Rezoning Transportation Analysis

Petition Number: Zoning Petition #2021-019

Date	Description
02-25-2021	First Review (KP)
08-23-2021	Second Review (KP)

REZONING SITE PLAN SCALE 1" = 60'

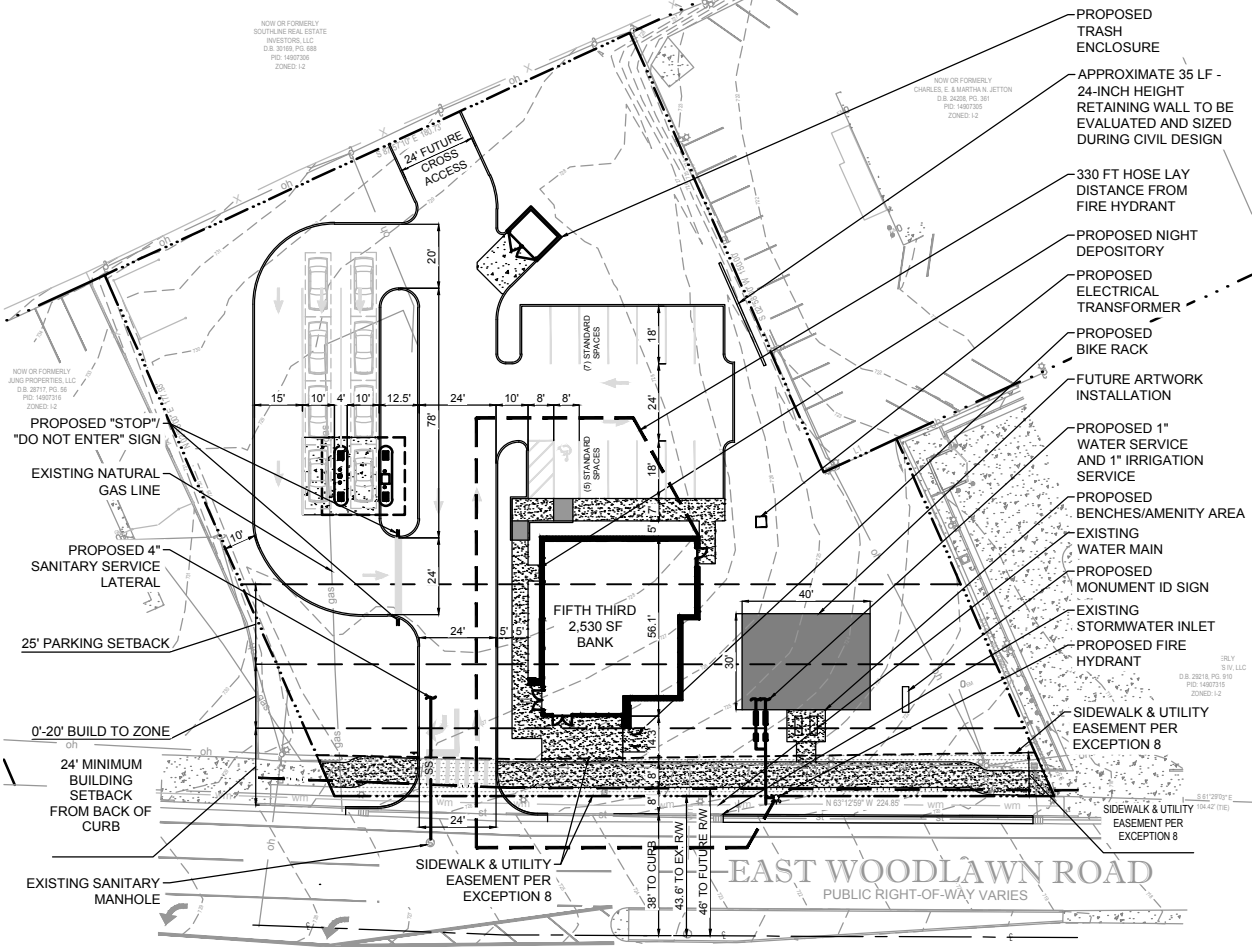
2. Including a conditional note that the proposed site access, off Woodlawn Road, will be subject to NCDOT recommendations and approval, to be coordinated during the permitting process.

3. A site plan note(s) specifying dedication and fee simple conveyance of all rights-of-way to the City and/or NCDOT before the site's first building certificate of occupancy is issued is needed. CDOT requests rights-of-way set at 2' behind back of sidewalk where feasible.

4. A site plan note specifying that all transportation improvements will be approved and constructed before the site's first building certificate of occupancy is issued is needed. The petitioner may phase transportation improvements if said improvements and phasing are explicitly described in site plan notes.

5. Revise the conditional notes by including the following note:
 All public roadway improvements will be subject to the standards and criteria of CDOT and NCDOT, as applicable, to the roadway improvements within their respective road system authority. It is understood that such improvements may be undertaken by the Petitioner on it's own or in conjunction with other development or roadway projects taking place within the broad south Mecklenburg area, by way of private/public partnership efforts or other public sector project support.
